Building Inspections - RE: 42 Seal Cove Ln.

The owner made some changes to the plan and we are filing the attached amended set of plans.

<b>Proposed Elevations</b> 1/4" = 1'-0"	<b>A2-001</b> 5/23/2013 5 of 6
--	-----------------------------------

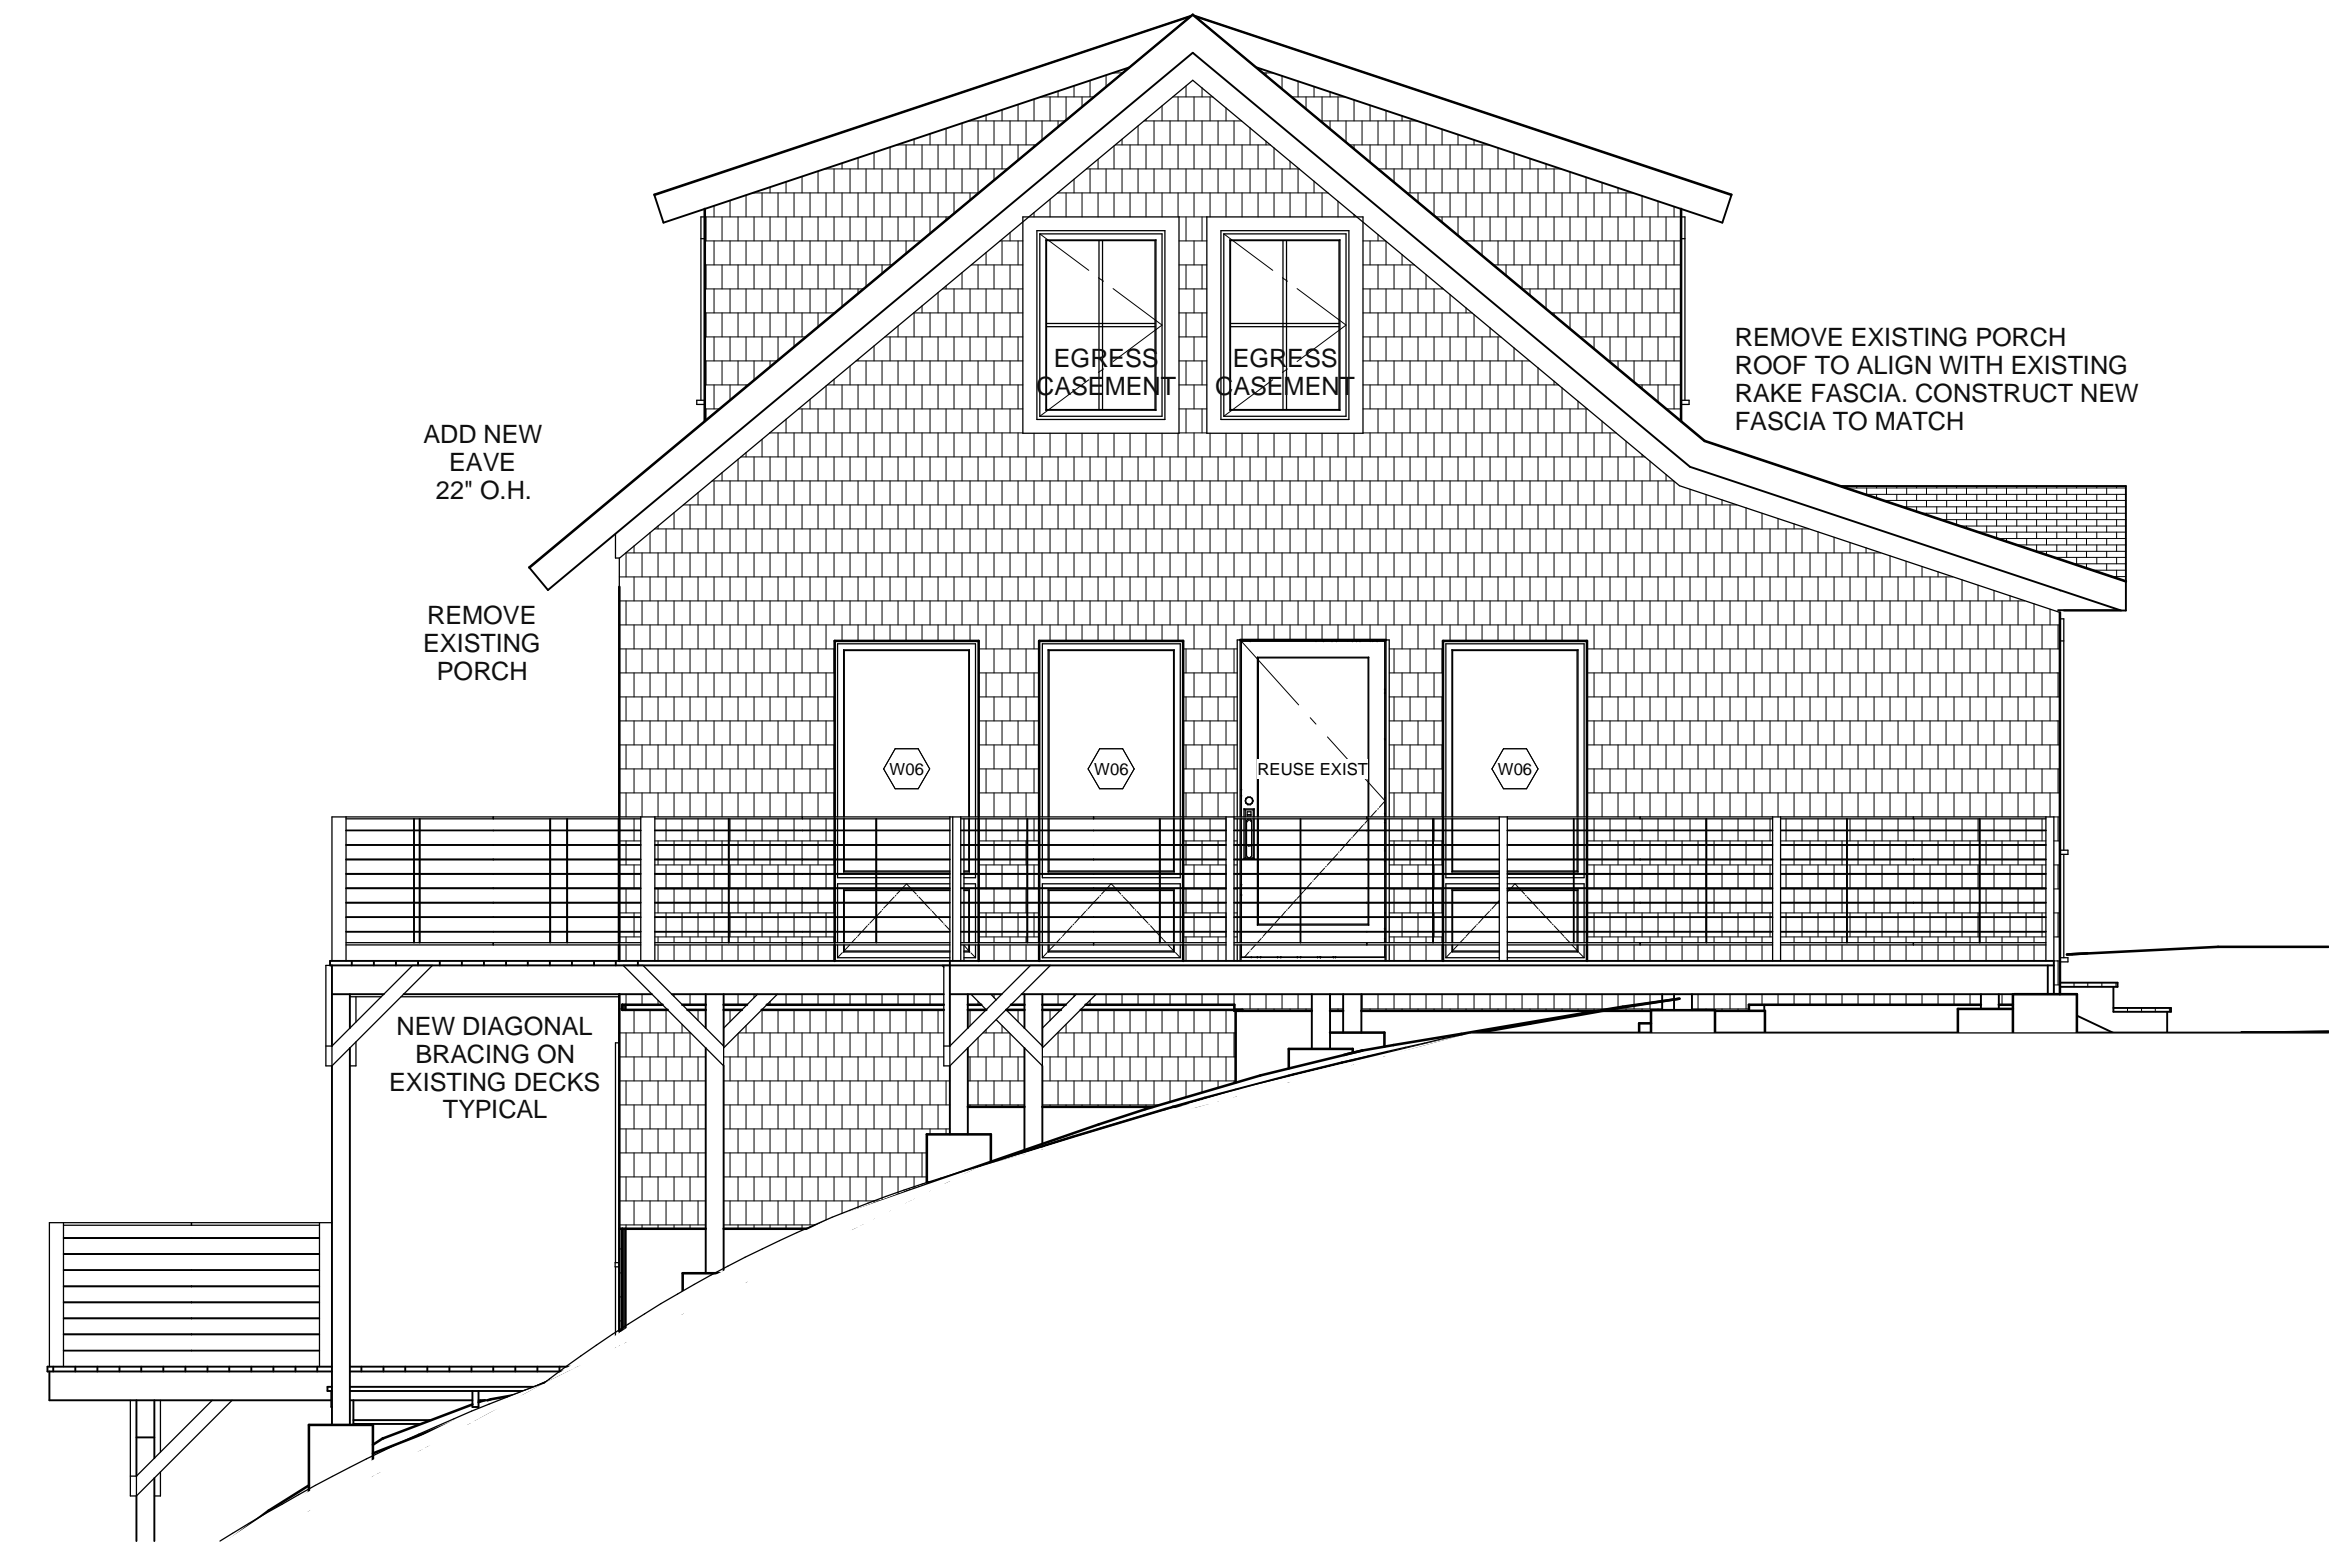
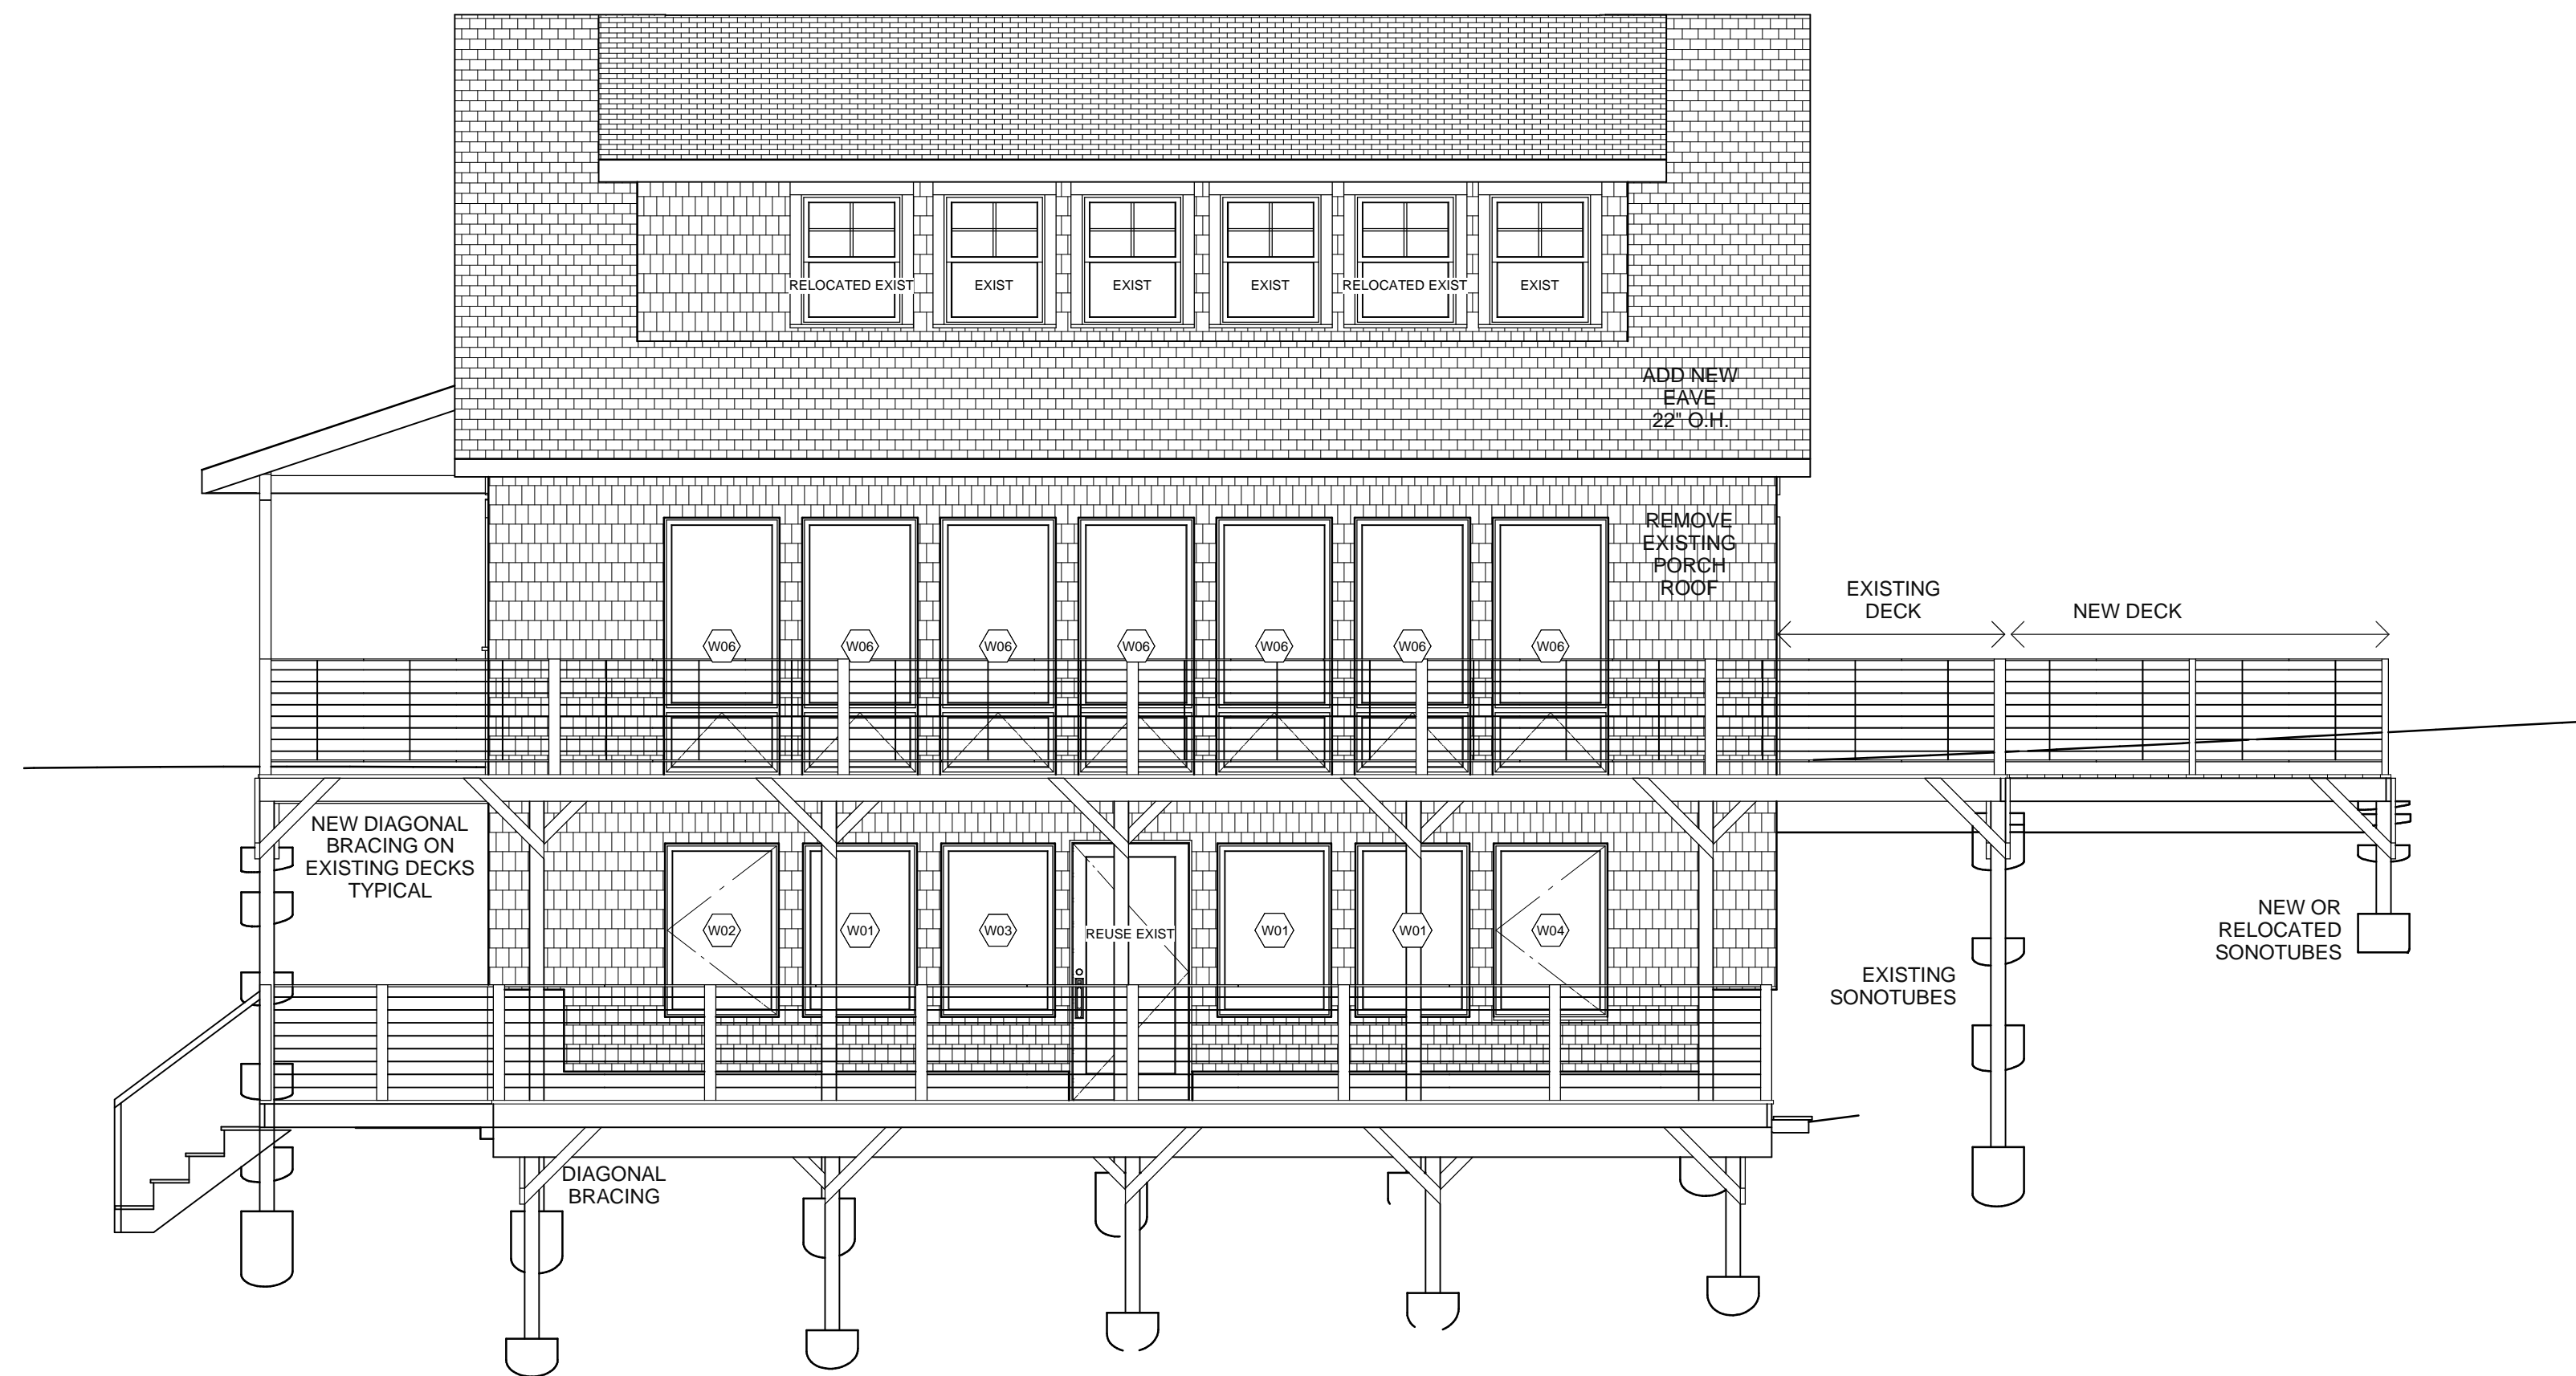
1. Enclosing the porch on the west elevation and putting a foundation under the existing roof.
2. Adding a small gable to the roof over the entry.
3. Leaving the existing porch on the main level on the east and north elevations.
4. Increasing the size of the deck on the South elevation.
5. Increasing the size of the deck on the ground level on the West elevation.
6. Moving the existing kitchen to the North-West Corner
7. Moving the bathroom to the enclosed porch.
